# Helmingham Hall Design & Access Statement

REVISION: P1

November 2022

Ben Pentreath

Ben Pentreath		3 Lamp Office Court Lamb's Conduit Street London WC1N 3NF T +44 (0) 20 7430 2424 benpentreath.com
PROJECT: HELMINGHAM HALL		
TITLE: PROPOSED BOOT ROOM EAST ELEVATION		
DRAWING NO: A-103.2	REV. NO: P1	
SCALE: 1:10@A1 1:20@A3	DRAWN BY: AM	
DATE: 02.11.22	CHECKED BY: RJC

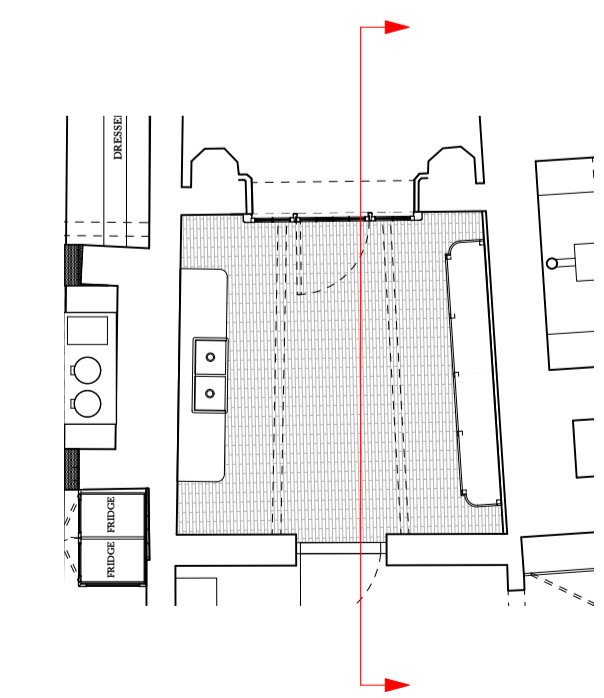
The glazed screen and creation of a boot room – NE elevation  
This element of work has been the subject of a large amount of discussion. Although this portion of the building seems to be later, there is evidence that this entrance has seen a lot of use, the floor is charmingly worn through the impact of generations of feet. Earlier proposals showed the floor and walls covered over, it is now heartening to see the floor left as existing. The design of the screen has been designed to mimic that of the door behind and placing it on the inside of the arch means that the frame will be barely visible. Although this is placed within another popular public viewpoint, the amount of glass and the style of the door, which mimics other doors on other elevations, means that the visual harm would be minimal.

TITLE: PROPOSED EXTERNAL NW ELEVATION

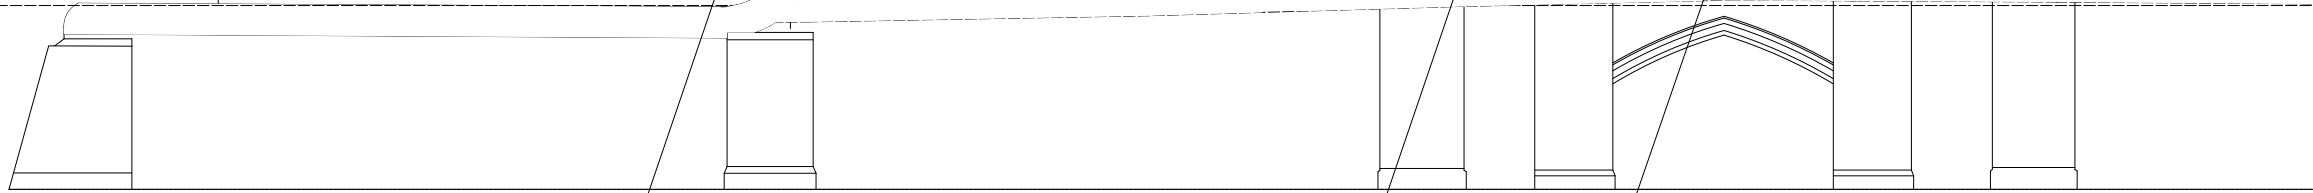
North west elevation (Excluding conservatory)

The opening up of blind windows, the conversion of one window to a door to match an existing door on the southern elevation and secondary glazing on the upper tier of windows would not, in principle, detrimentally alter the visual character of the building from this important public facing elevation. Although the conversion of a window to a door would result in some loss of historic fabric at the base of the door, this is considered to be minimal. The works are proposing to reuse the original window and existing mullions however, the section drawing shown seems to be showing double glazing and slightly thicker profile glazing bars. This needs to be reviewed as when compared with other windows in the run at this point, it could be noticeable. On the elevation drawings provided the lines are darker but this could just be drafting. Drawings for the ground floor windows should also be provided at application and we suggest that single glazing should be used.

Our proposal drawings and documents have been updated in response to the advice received from Historic England. We have also decided against the use of under-floor heating in the main kitchen to avoid the loss or damage of the historic clay pavement floor.

Ben Pentreath		3 Lamp Office Court Lamb's Conduit Street London WC1N 3NF T +44 (0) 20 7430 2424 benpentreath.com
PROJECT:	HELMINGHAM HALL	
TITLE:	KITCHEN PROPOSED PROPOSED PLAN	
DRAWING NO: A-101	REV. NO:	P1
SCALE:	1:25@A1 1:50@A3	DRAWN BY: AM
DATE:	02.11.22	CHECKED BY: RJC

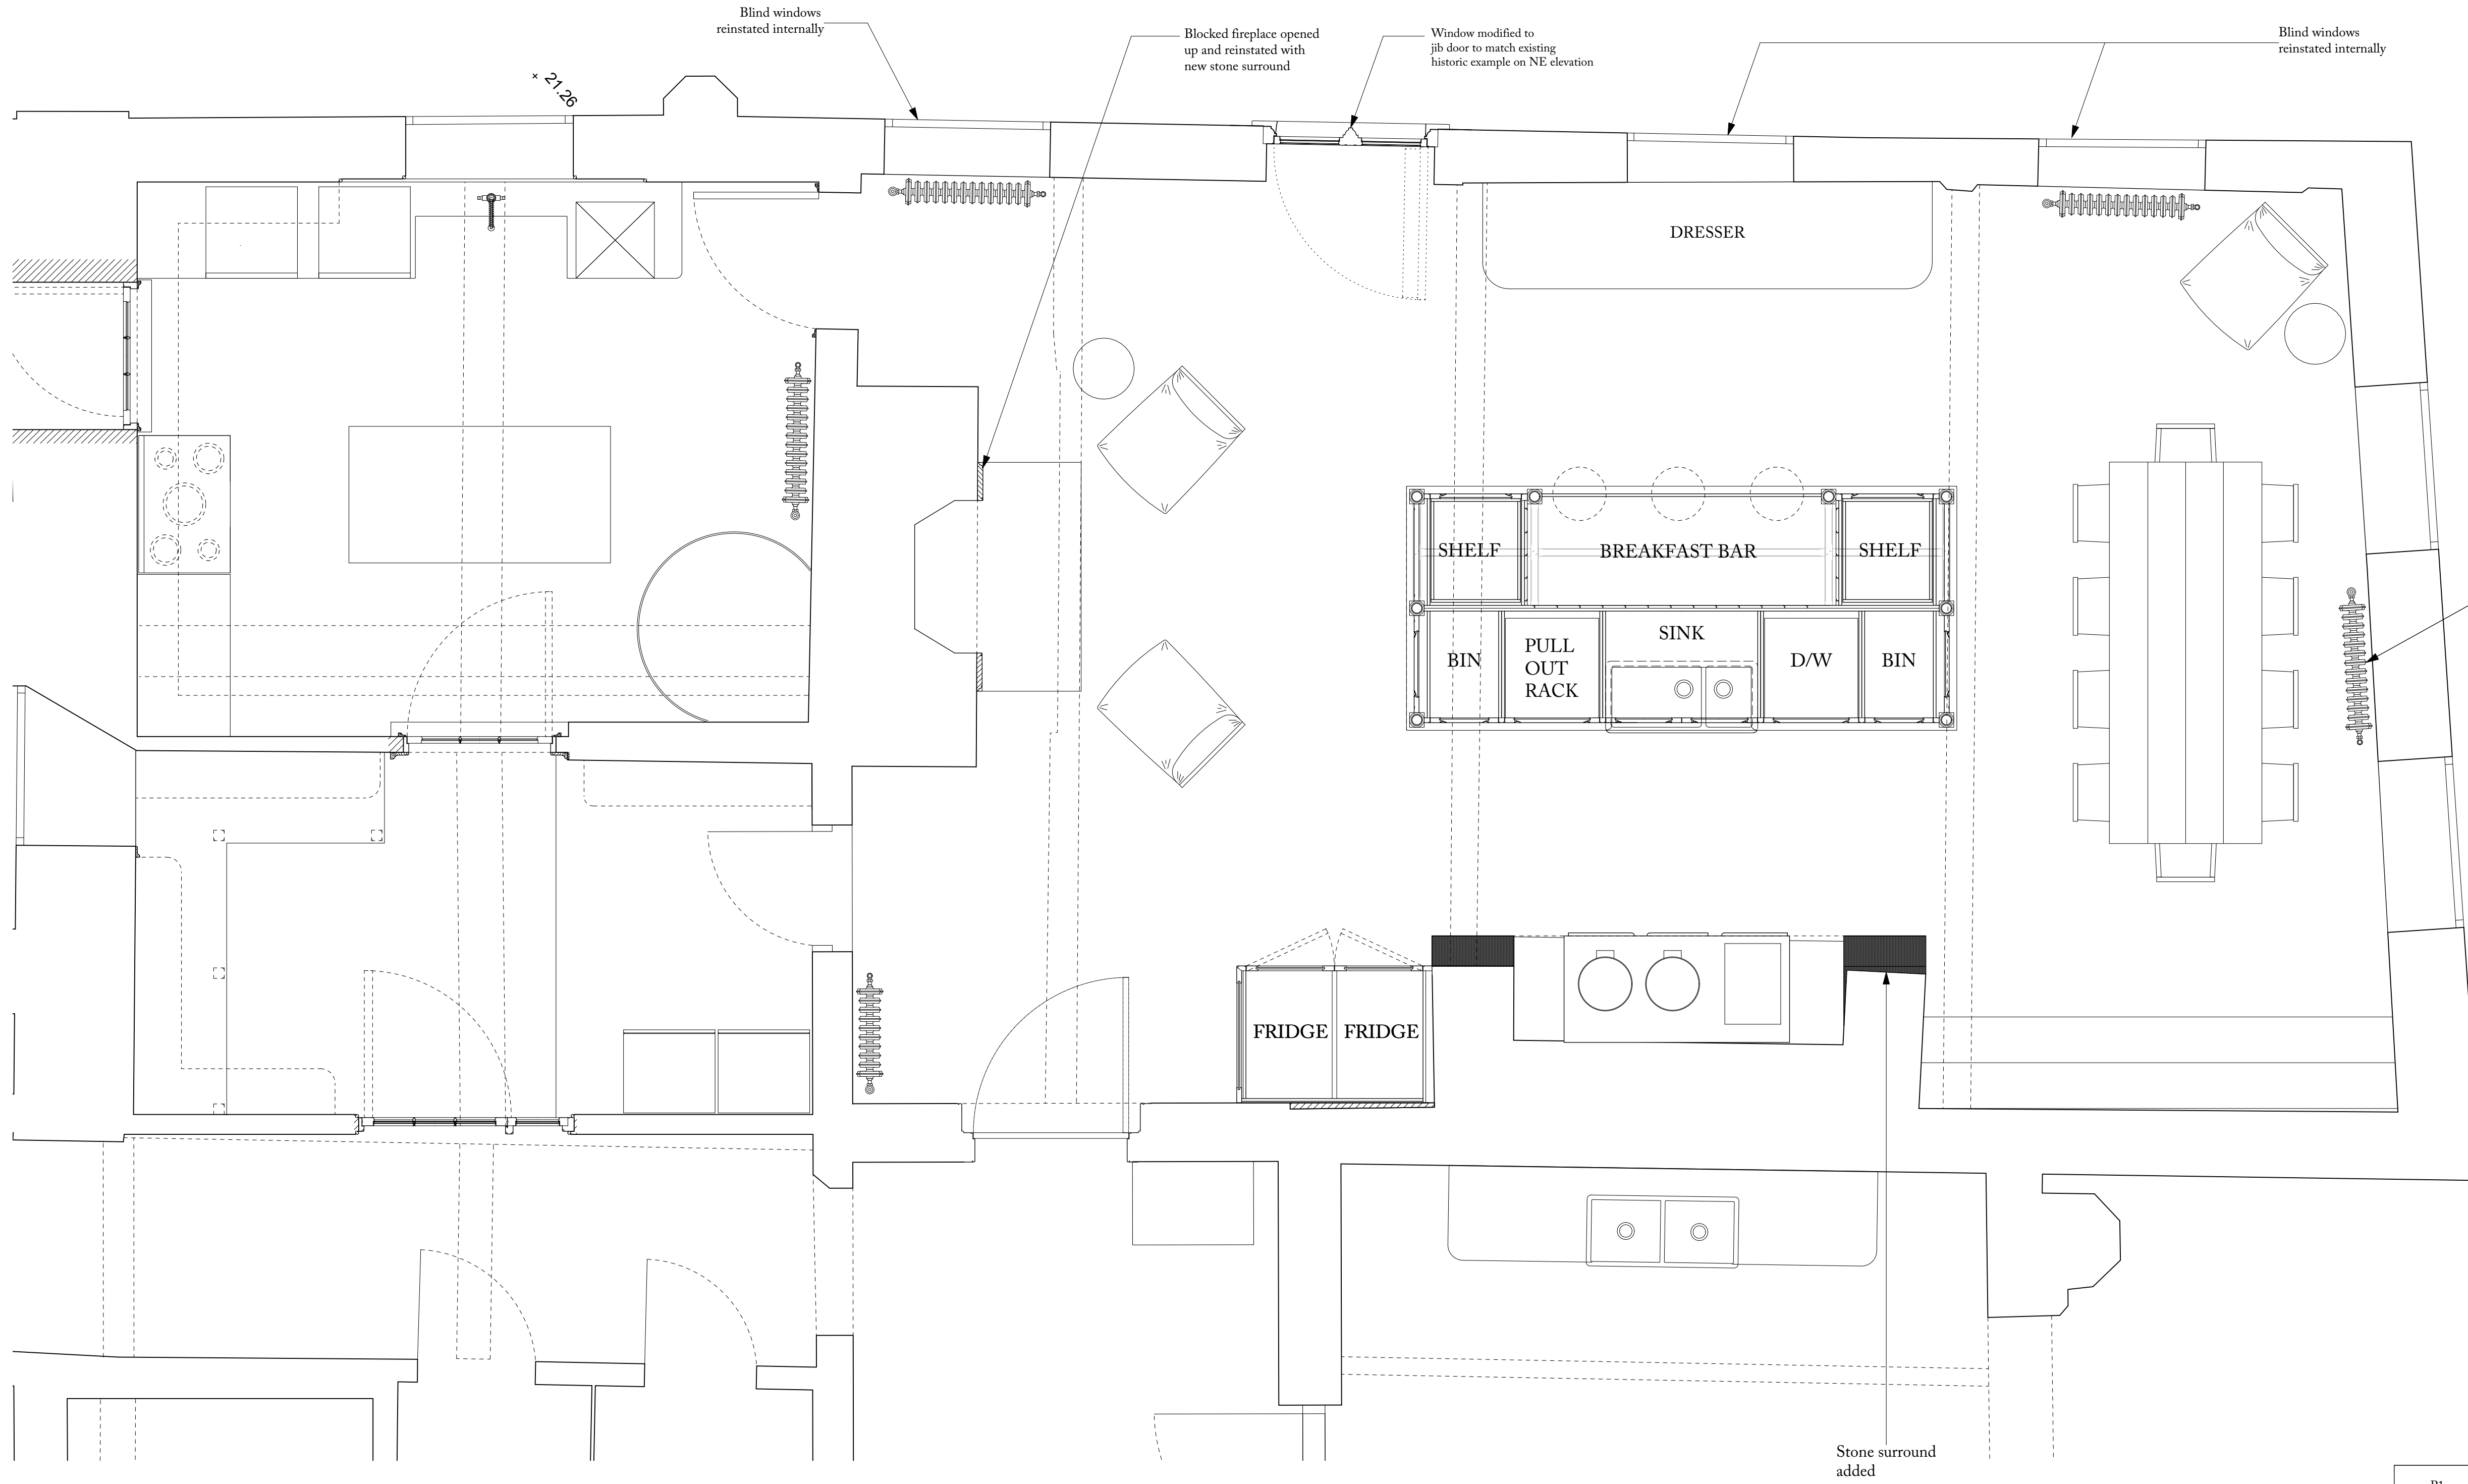
The internal changes would not result in harm to the significance of the building. The installation of underfloor heating has not been discussed at any length as these discussions were focussed in other areas and consideration will need to be given to whether this would raise the floor level and cause alterations to be required in other places. I would be happy to discuss this with you at another point if this would be useful.
